STATE OF NORTH CAROLINA
DEPARTMENT OF TRANSPORTATION

Addendum No. 1

RE: Contract ID: C202808
WBS# 45458.3.1
F. A. # NHS-0158(54)
Currituck County (R-5517)
US-158 From US-168 To The Wright Memorial Bridge

January 17, 2012 Letting (Advertisement extended from the December 20, 2011 Letting)

TYPICAL SECTION NO.1

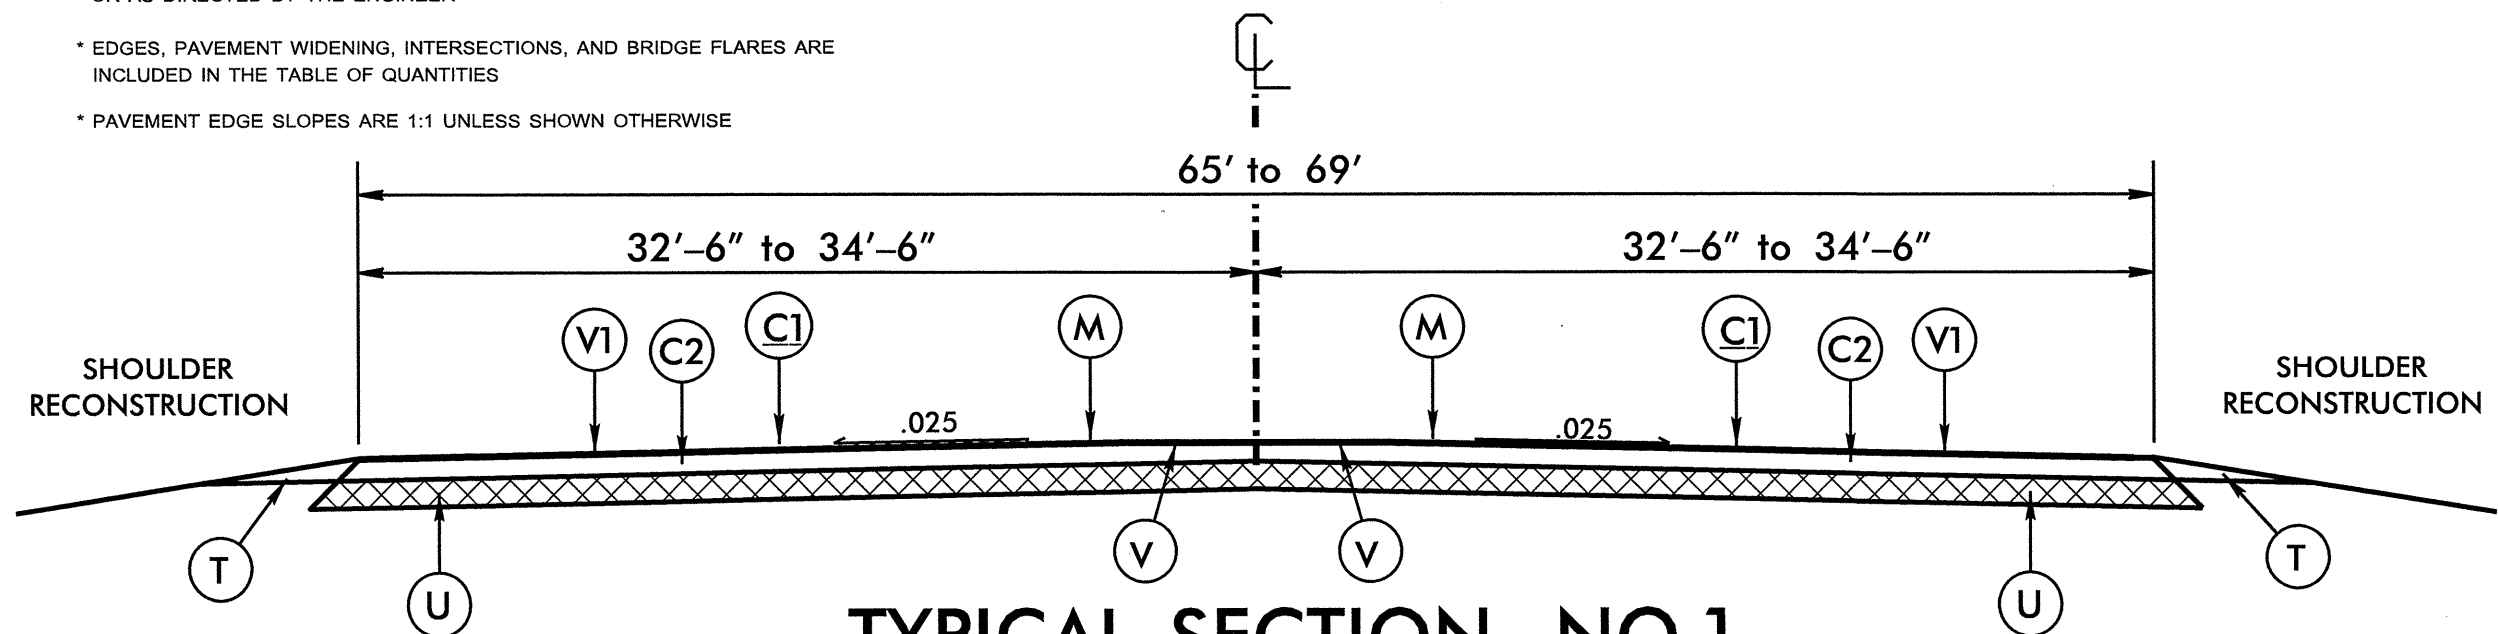
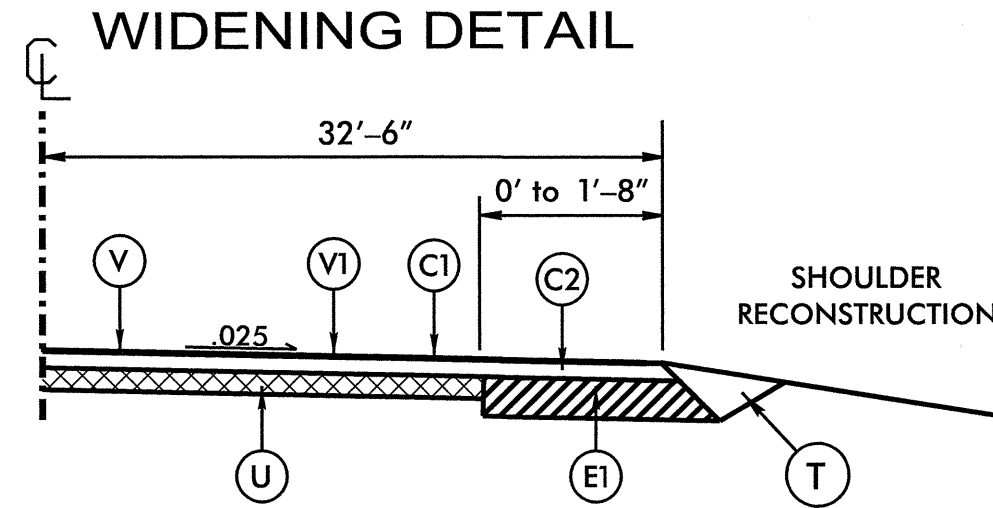
On Sheet Nos. 3, 4 and 5 the cross slope was changed in the typical section. Please void Sheet Nos. 3, 4 and 5 in your plans and staple the revised Sheet Nos. 3, 4 and 5 thereto.

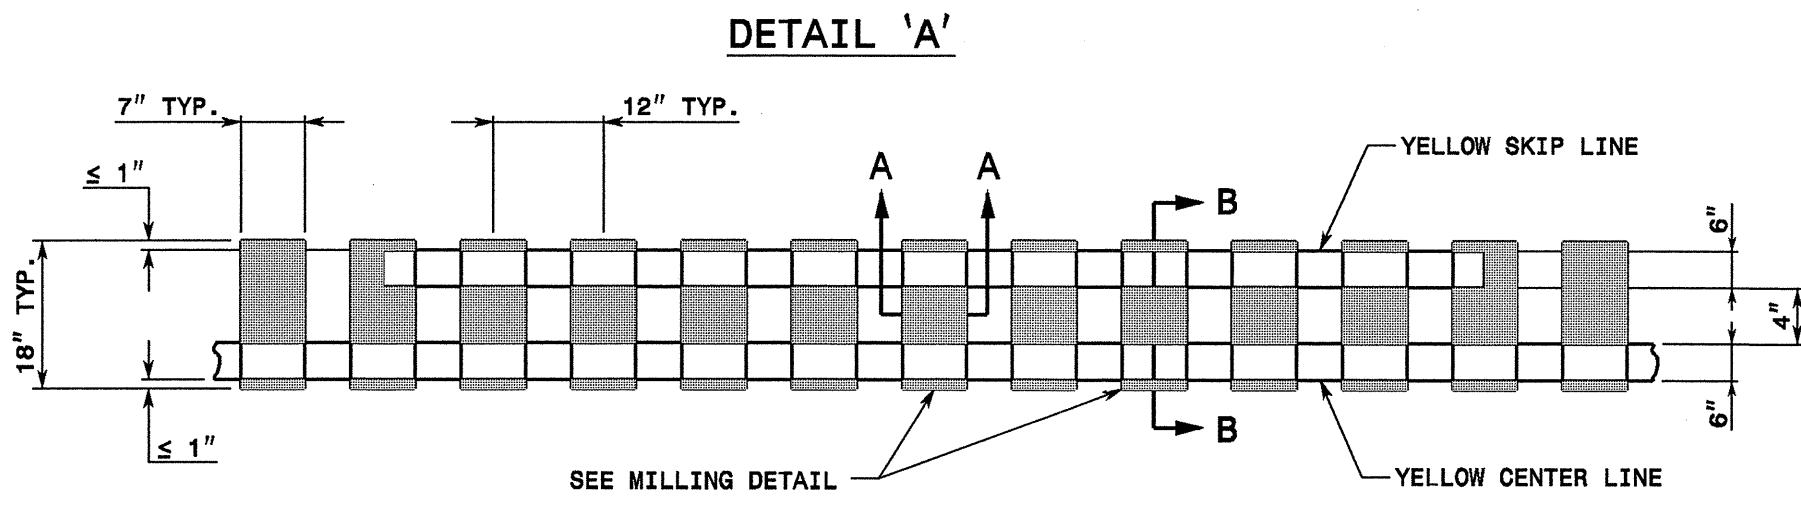
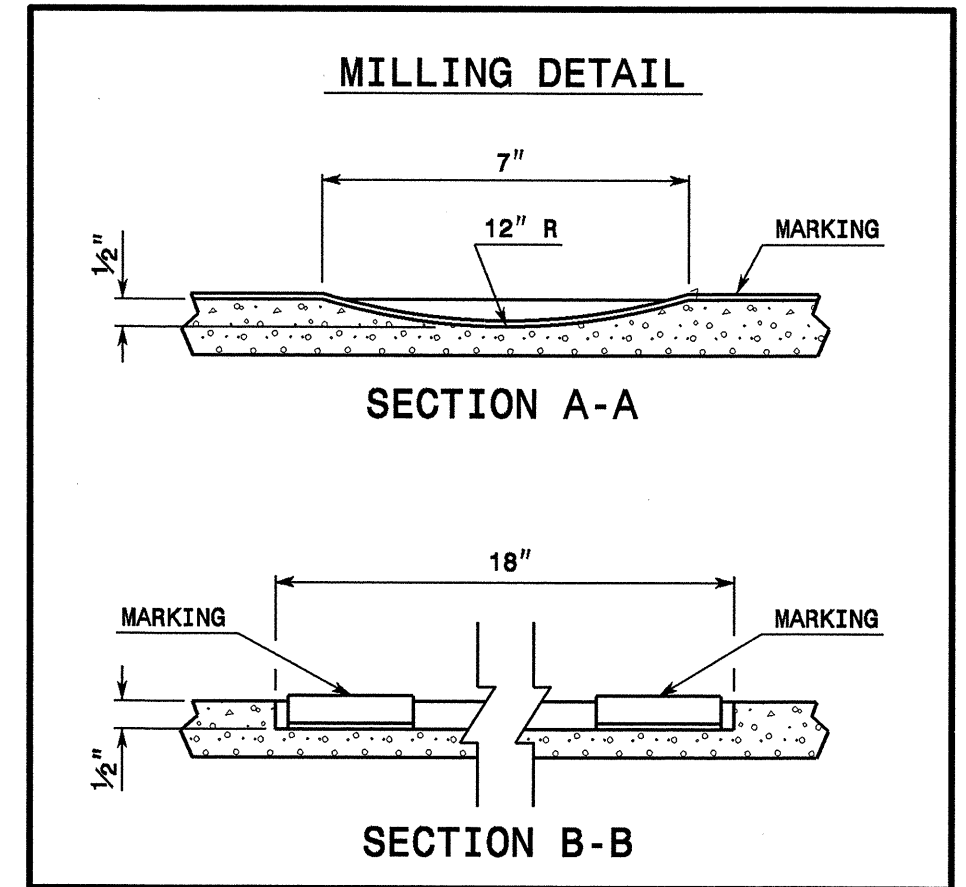
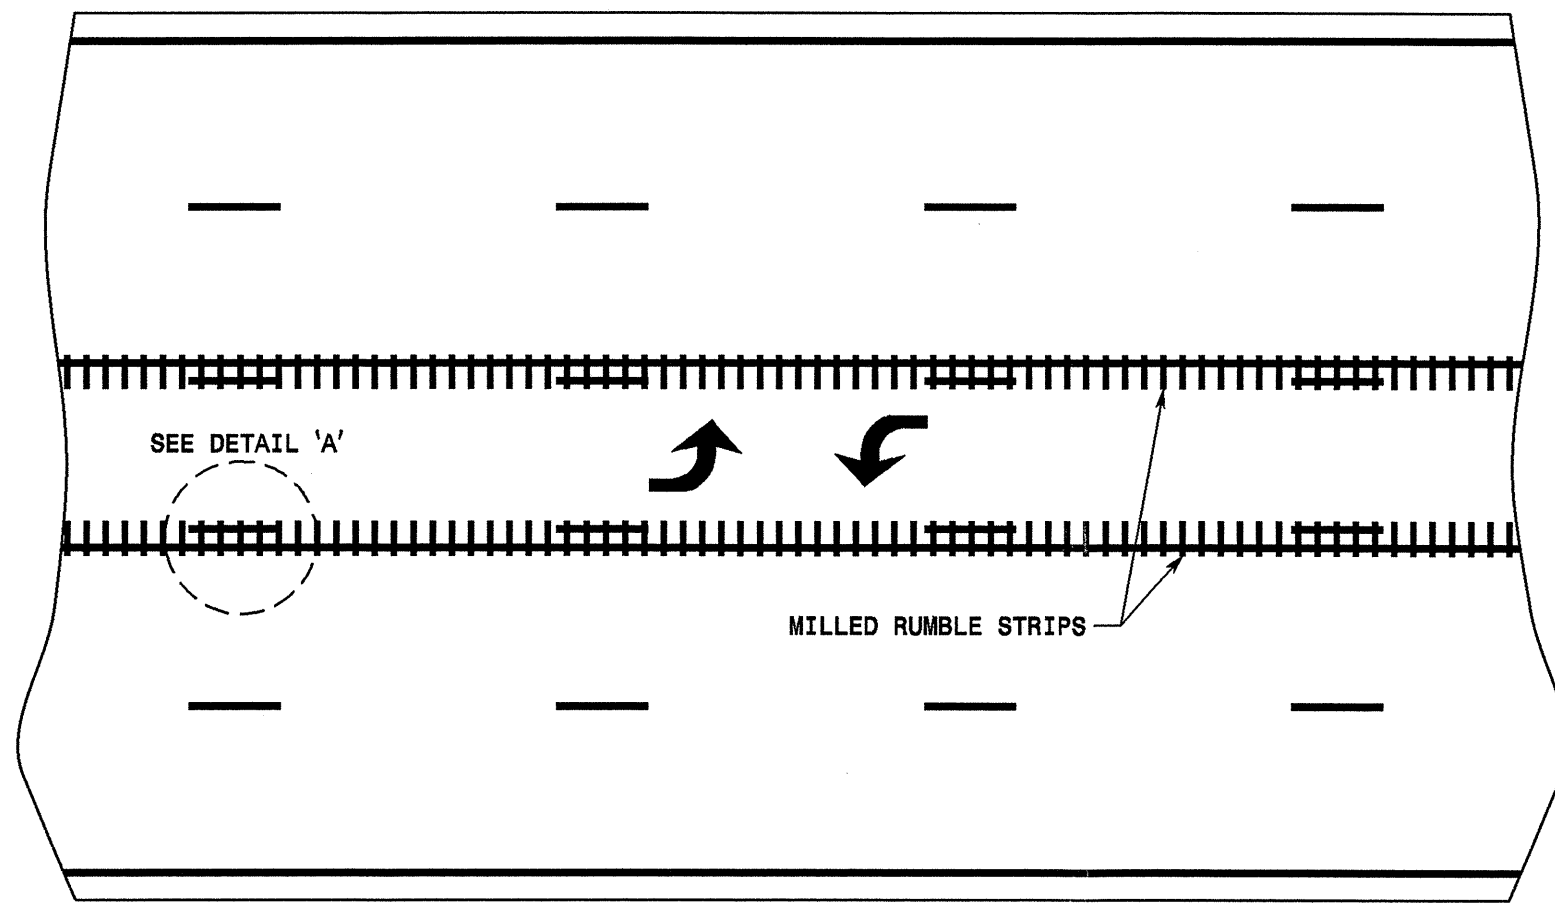
On Sheet No. 6 the "Summary of Quantities" has been revised to reflect the below noted quantity changes and additions. Please void Sheet No. 6 in the sketch maps and staple the revised Sheet No. 6 thereto.

<u>Item</u>	<u>Description</u>	<u>Old Quantity</u>	<u>New Quantity</u>
3-0156000000-E-250	Removal Of Existing Asphalt Pavement	120 SY	DELETED
4-0318000000-E-SP	Foundation Conditioning Material, Minor Strs.	22 TON	26 TON
5-0320000000E-SP	Foundation Conditioning Fabric	50 SY	66 SY
6-0378000000-E-SP	24" RC Pipe Culverts, Class III	60 LF	76 LF
10-1297000000-E-607	Milling Asphalt Pavement, 1 1/2" Depth	949,252 SY	DELETED
10-1308000000-E-607	Milling Asphalt Pavement, 1 1/2" to 0" Depth	NEW ITEM	747,888 SY
14-1523000000-E-610	Asphalt Concrete Surface Course, Type S9.5C	87,369 TON	86,781 TON
15-1575000000-E-SP	Asphalt Binder For Plant Mix	5,160 TON	5,126 TON
25-4810000000-E-1205	Paint Pavement Marking Lines (4")	2,097,404 LF	1,721,602 LF
28-4847220000-N-1205	Polyurea Pavement Marking Symbol (Highly Reflective Elements)	877 EA	DELETED
28-4725000000-N-1205	Thermoplastic Pavement Marking Symbol (90 MILS)	NEW ITEM	877 EA

40-0372000000-E-SP	18" RC Pipe Culverts, Class III	NEW ITEM	32 LF
41-2286000000-N-840	Masonry Drainage Structures	NEW ITEM	2 EA
42-2374000000-N-840	Frame with Grate and Hood, Std. 840.03, Type E	NEW ITEM	2 EA
43-2549000000-E-846	2'-6" Concrete Curb and Gutter	NEW ITEM	40 LF
